**Consultation Response from KC,
Lead Local Flood Authority**
2020/90119 Former Petrol Station, North Road, Kirkburton, Huddersfield, HD8 0RL
Discharge conditions 12-16 on previous permission 2016/93935 for demolition of existing petrol station and erection of 4 retail and residential units (within a Conservation Area) (modified proposal)
**Date Responded: 28
January 2020**
**Responding Officer:
Aleksandra Tomczyk**
Responding Ref: 0
Summary

- Drawing *Drainage Layout*, prepared by Empace Consulting, number ESE-DR-S-001, version P1, dated 24/12/2019; and
- MicroDrainage outputs, dated 06/01/2020.

Title: DRAINAGE LAYOUT			
Job No: 2242	DRN: MM	Date: 24/12/2019	
Scale: 1:125 (A1)	CHK: UD	DRG. No.: ESE-DR-S-001: P1

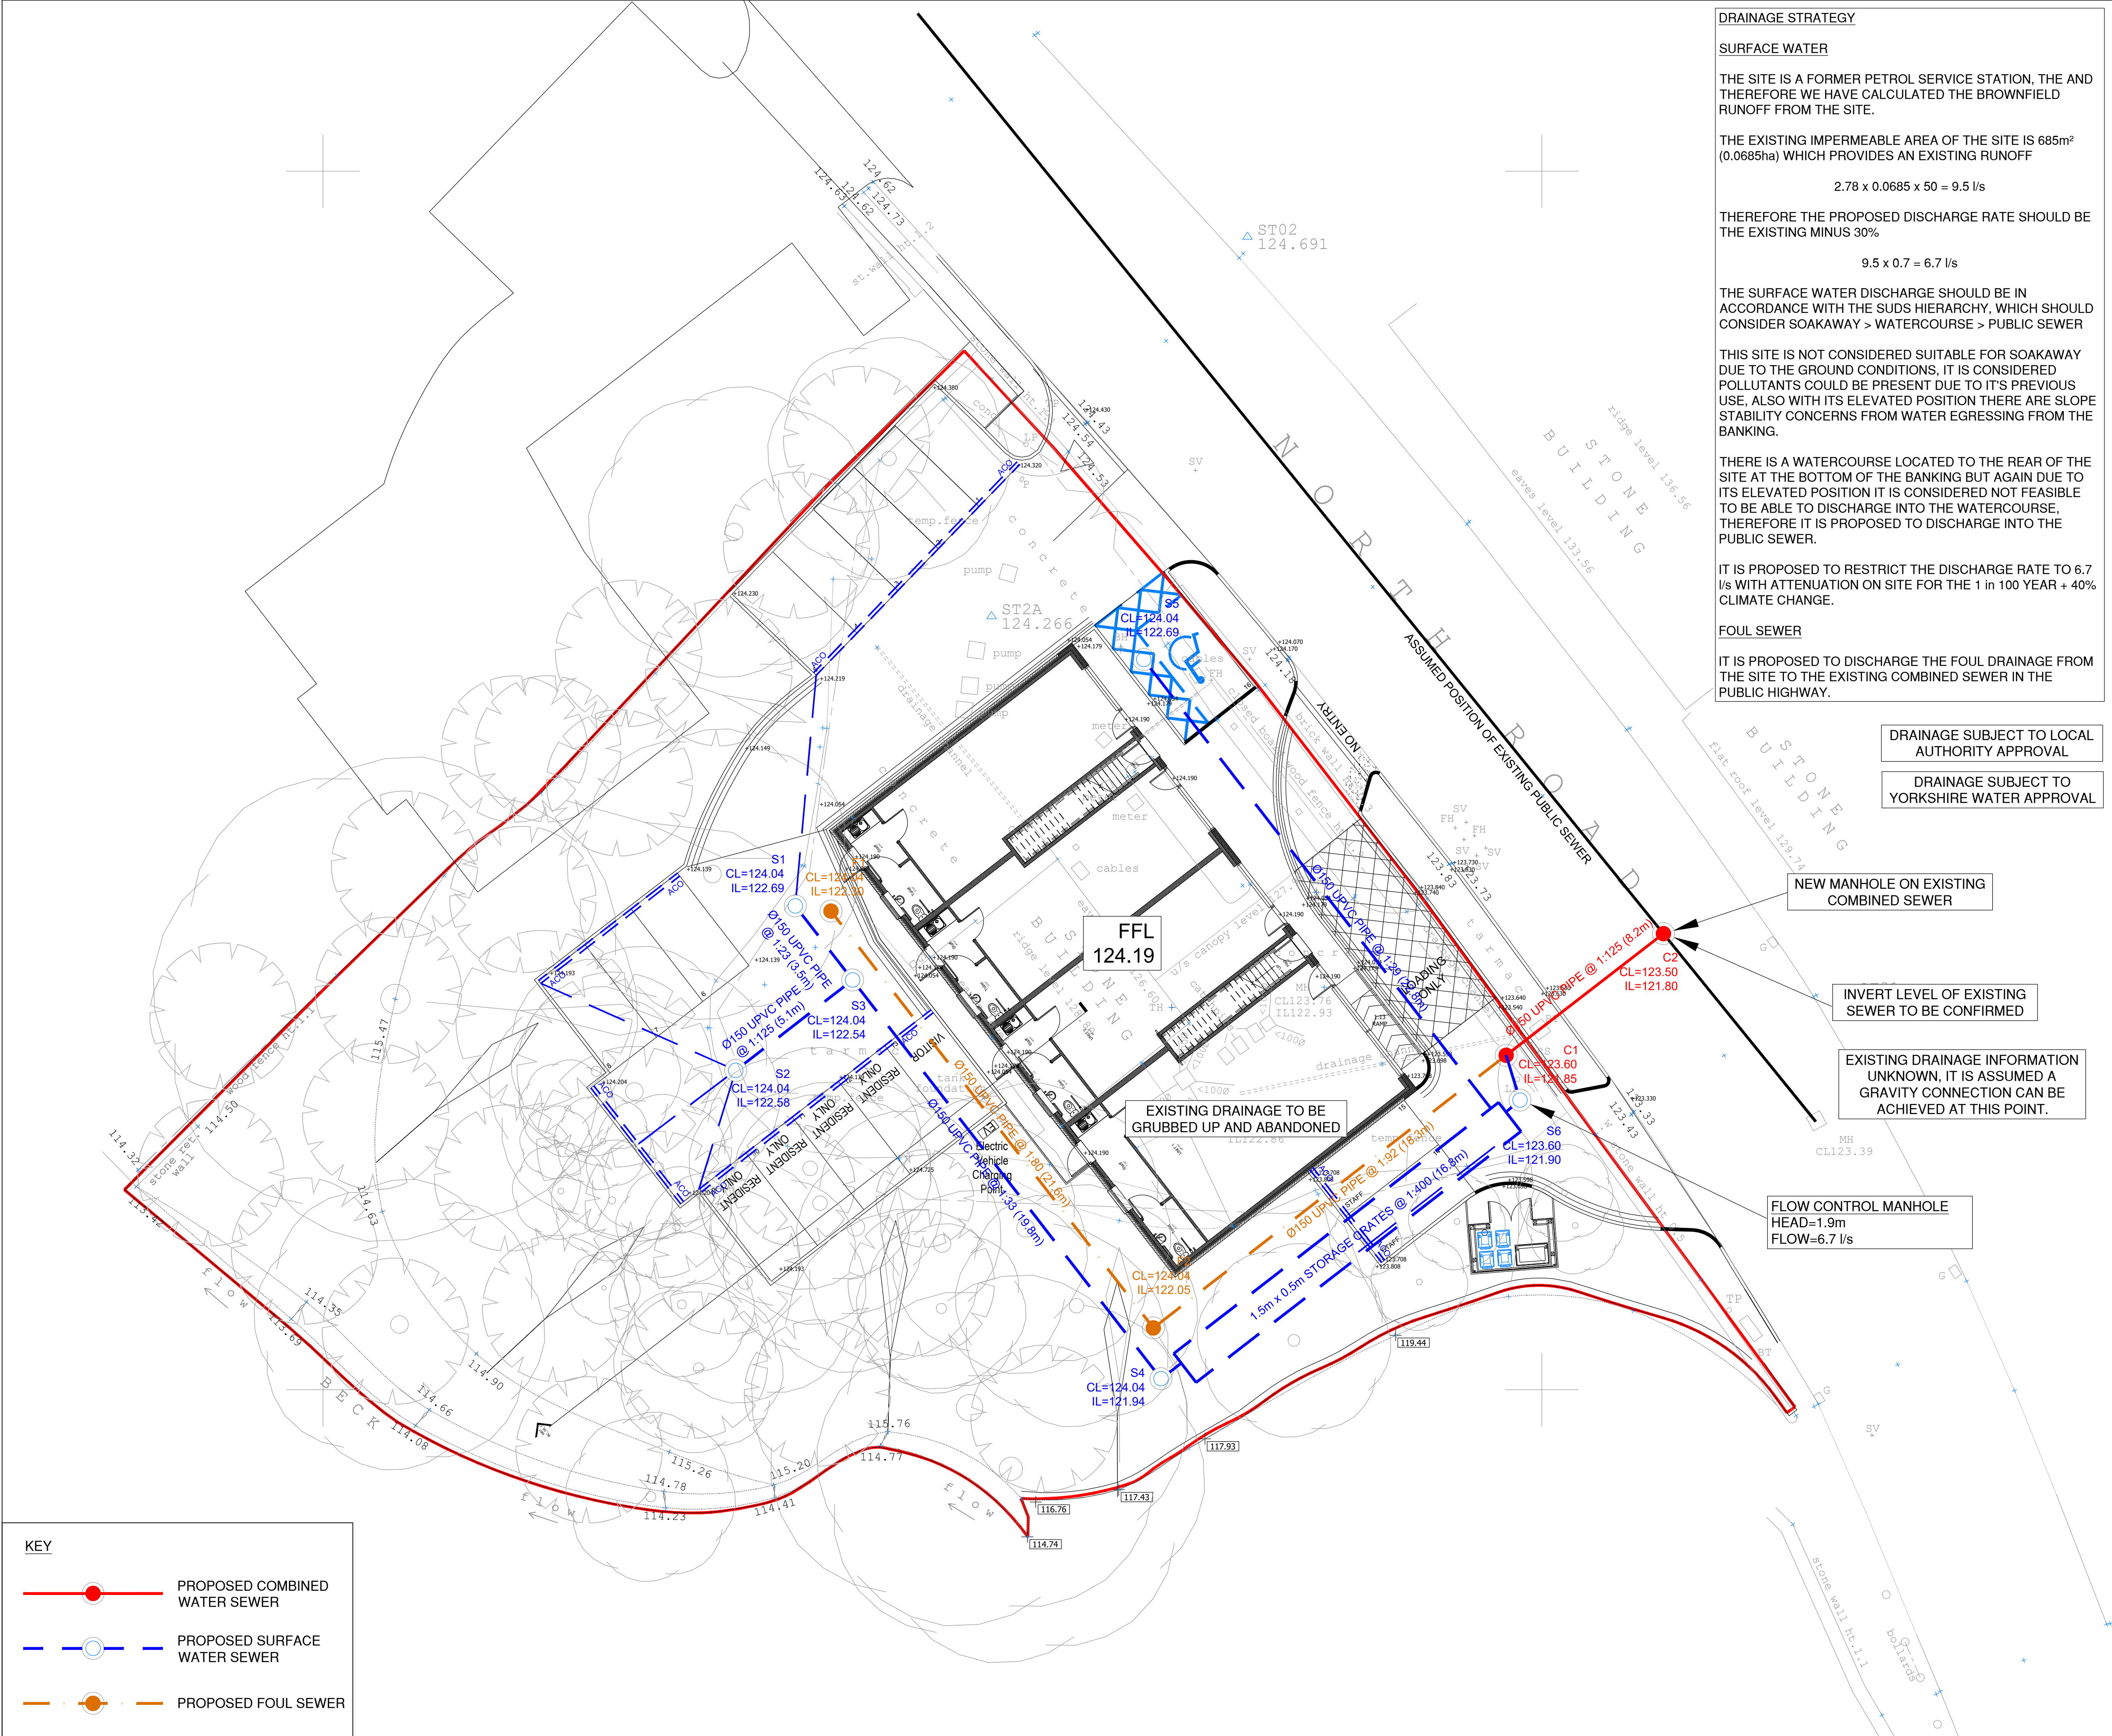
- The drainage drawing should show pipe numbers, corresponding to the MicroDrainage outputs.
- All pipe joints require manhole chambers.
- The drainage drawing shows an ACO drain running perpendicular to the dwellings, in the location of the storage crates. The drawing does not appear to show where this channel will discharge into. The applicant should confirm this and revise the design and drawing, if needed.

- Kirklees LLFA have **no objection to the proposed surface water discharge rate of 6.7 l/s**, as shown in the Drainage Strategy section of the *Drainage Layout* drawing.

- The applicant must confirm if the drainage is to be adopted or remain private.
- Within the General Notes – Drainage Works section of the drainage drawing, point 32 states that "All concrete and concrete products below ground level shall be class DS-4 and AC-4 sulphate resistance", while the point 11 states that they should be DS-1 and AC-1. The applicant should confirm this and provide an updated drawing.

- There is no information on the pipe 1.003 in the drawing.

- Manhole sizes should be also included in the drawing.
- Cover Level of manhole S6 differs between the drawing (123.60) and the MicroDrainage output (124.040). the applicant should confirm this and provide updated documents.
- The 'total area contributing' value within the MicroDrainage results is equal to 0.092ha, which is different than the total impermeable area stated in the *Drainage Layout* drawing (0.0685ha). The applicant should review this and confirm the reasoning for this difference. The applicant should revise the design and provide updated documents.

There is no information on the required attenuation sizing – this should be provided to show that the proposed storage crates are sufficient. Taking into account porosity, the proposed crates could provide at a lower end 11.59m³ (92% porosity) and maximum 11.97m³ (95% porosity).

Additionally, the applicant should confirm if there is a specific reason why oversized pipes were not considered for attenuation. Oversized pipes are commonly easier to manage and maintain, as well as having no internal structural latticing and therefore no reduction in porosity.
